From: "Lyn Barden" <Lyn_Barden@barker.nsw.edu.au>
To: <plan_comment@planning.nsw.gov.au>
Date: 3/12/2012 10:25 AM
Subject: ATTENTION: DIRECTOR INFRASTRUCTURE PROJECTS

Submission to NWRL -objection to buses on Robert Road

Application number: SSI-5414

Figure 6.12 Cherrybrook Station - Indicative vehicle and pedestrian movements

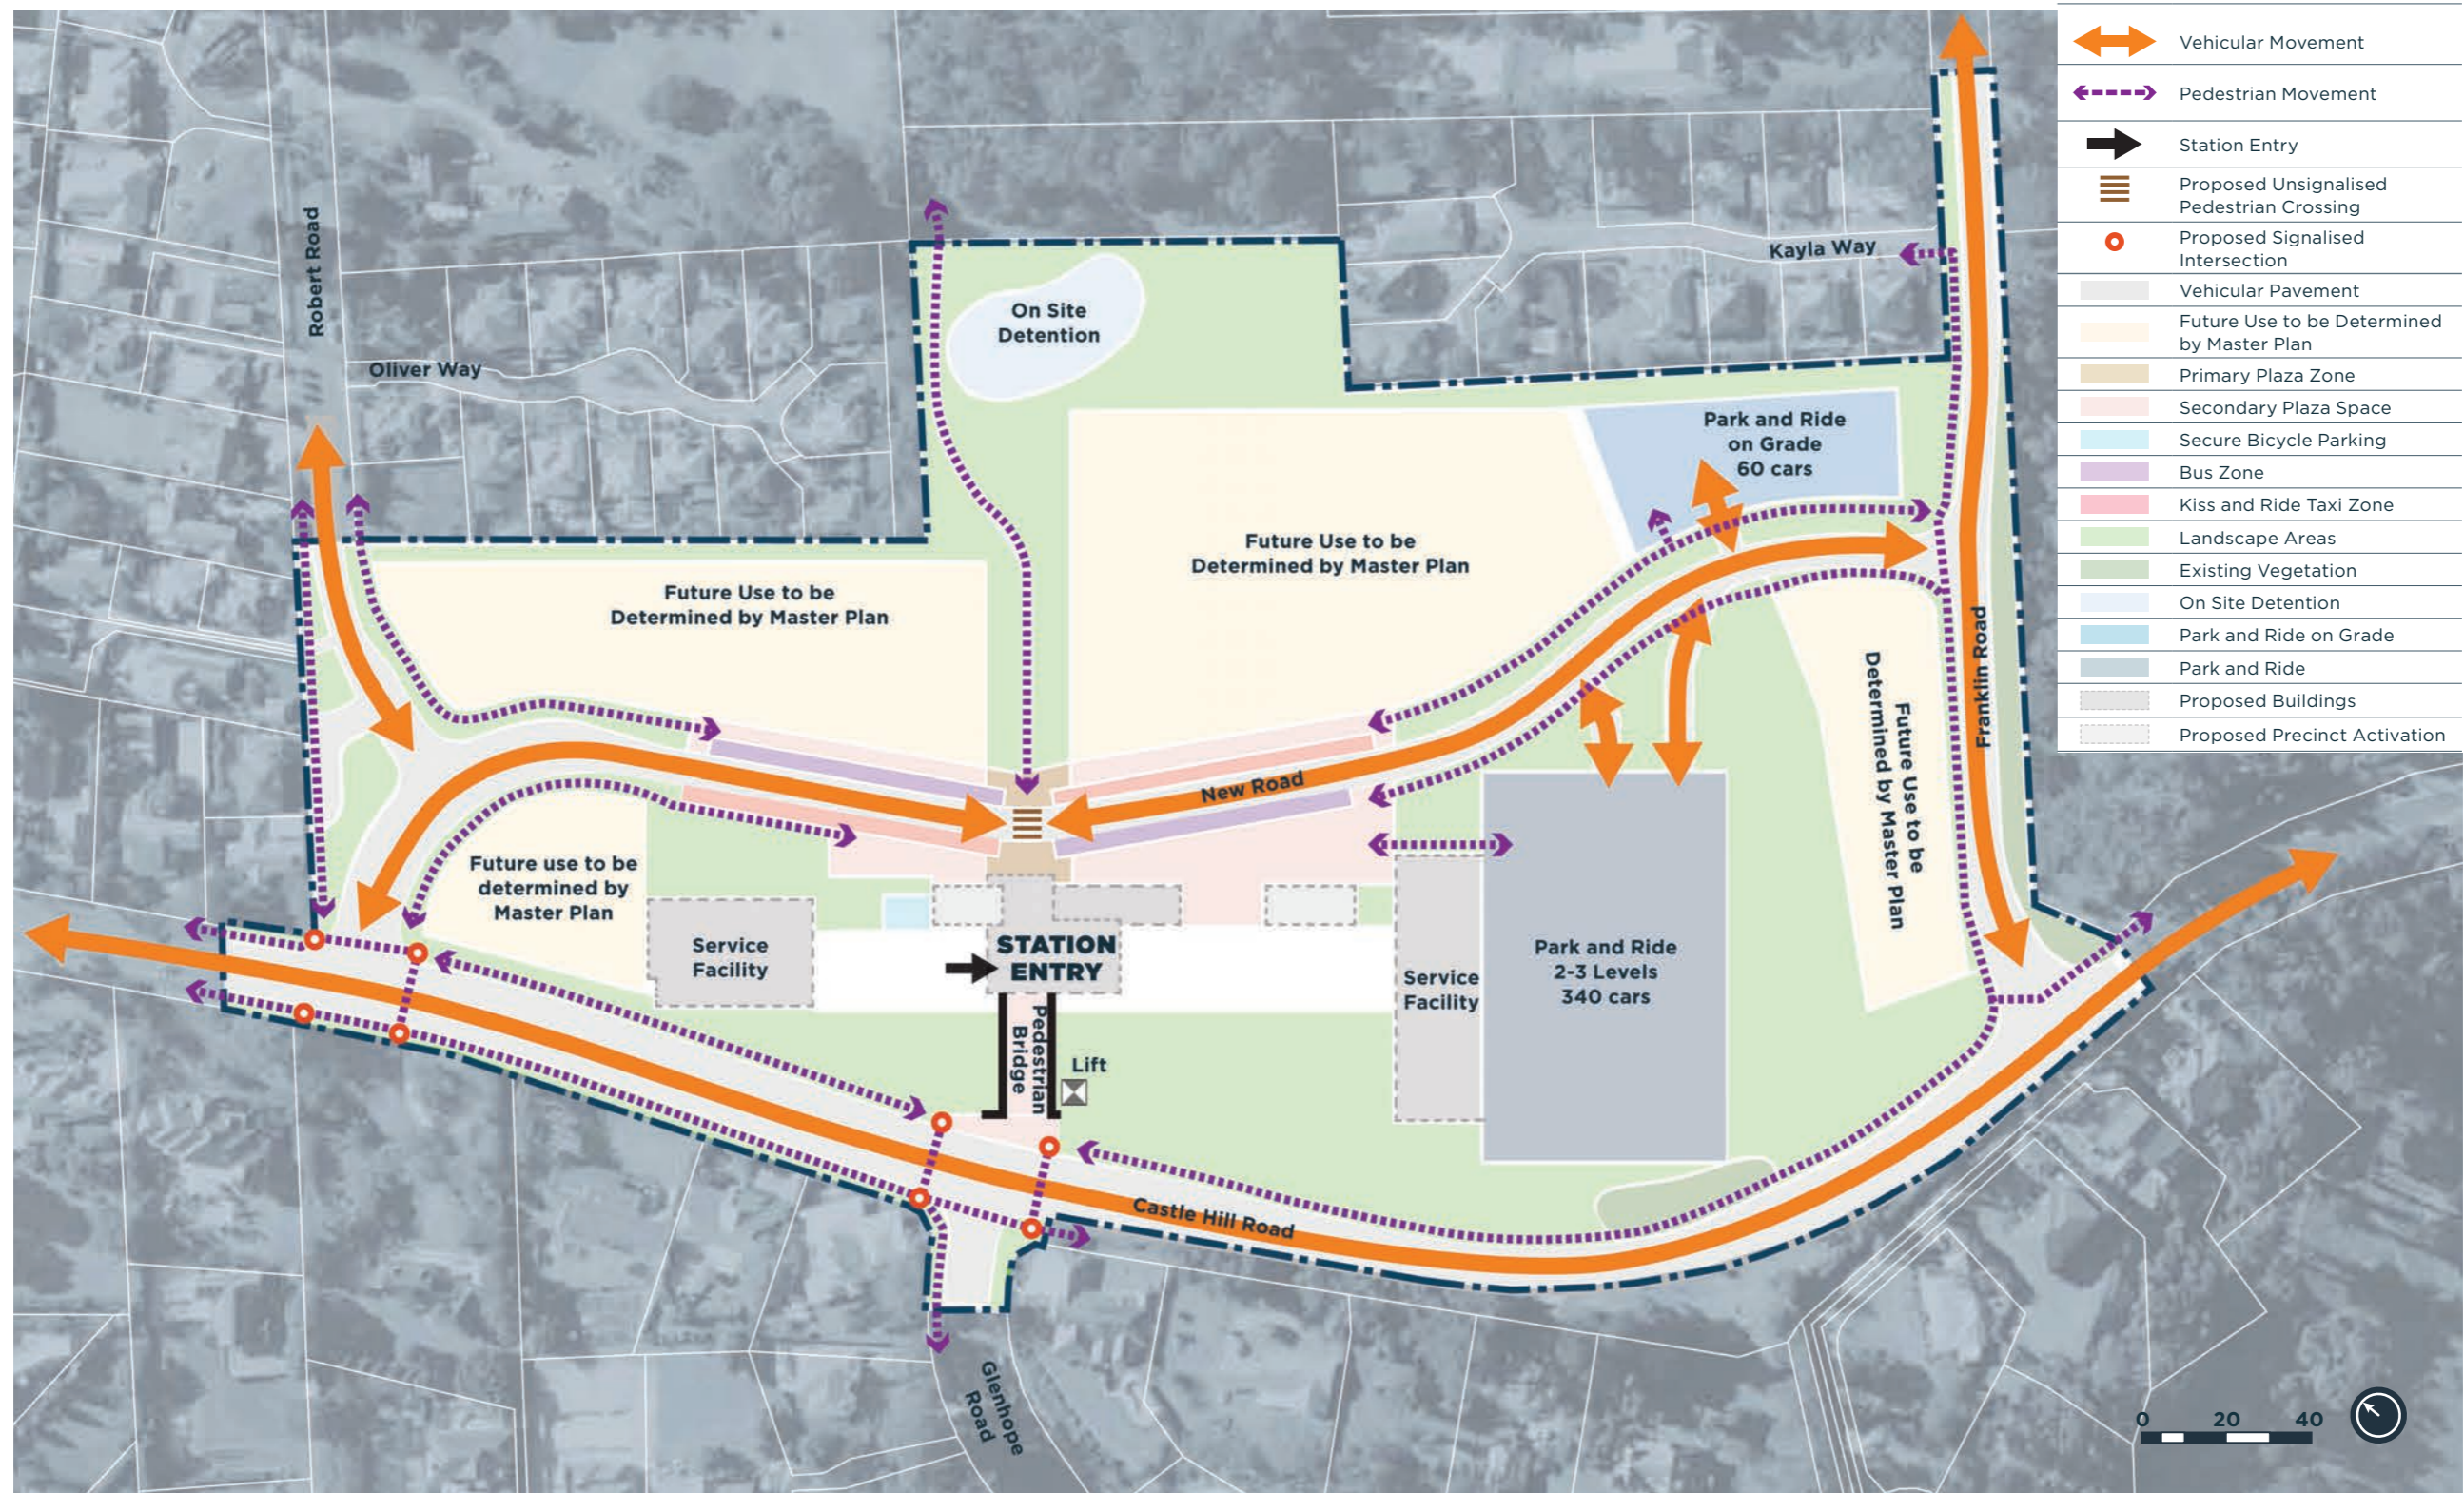
I vehemently object to the NWRL proposal to use Robert Road as an access Road to the proposed Cherrybrook Station. To underscore the illogical nature of the proposal by NWRL, I ask one question. Why would this senseless upheaval to residents be even considered when the logical option is the existing access of County Drive?

1. Robert Road is a narrow road designed for low numbers of vehicles. Unlike County Drive, it is not and was not designed for heavy traffic, particularly large vehicles such as buses.

2. County Drive and then Castle Hill Road route is logical. County Drive is clearly designed for heavy traffic. Robert Road is not. Buses heading south on County Drive could easily continue and turn left into Castle Hill Road and head towards Cherrybrook station, instead of the NWRL proposal of buses heading south on County Drive turn left into John Road and right into Robert Road and then south into Robert Road and onto Cherrybrook Station. Someone should have a look at the difficulty of the County drive John Road turn and it may result in reasonable rethinking.

3. Contrary to the NWRL proposal, traffic heading South on County drive turning left into Castle Hill Road at peak traffic times encounters very little traffic. And traffic heading east on Castle Hill Road in morning peak time does not slow down until after the station site has been passed. Traffic turning right onto Castle Hill Road does encounter delays, but this is in the opposite direction!

4. Safety issues are paramount. Robert Road is a quiet street, with pedestrians crossing the road at many points.
5. Cars exiting Arundel Way will not be able to exit safely. The increased traffic of large vehicles will obstruct vision. This also applies to residents of other cul-de-sacs off Robert Road such as Louise Way and Oliver Way. Accidents are bound to happen with the toxic combination of large vehicles and a narrow street.
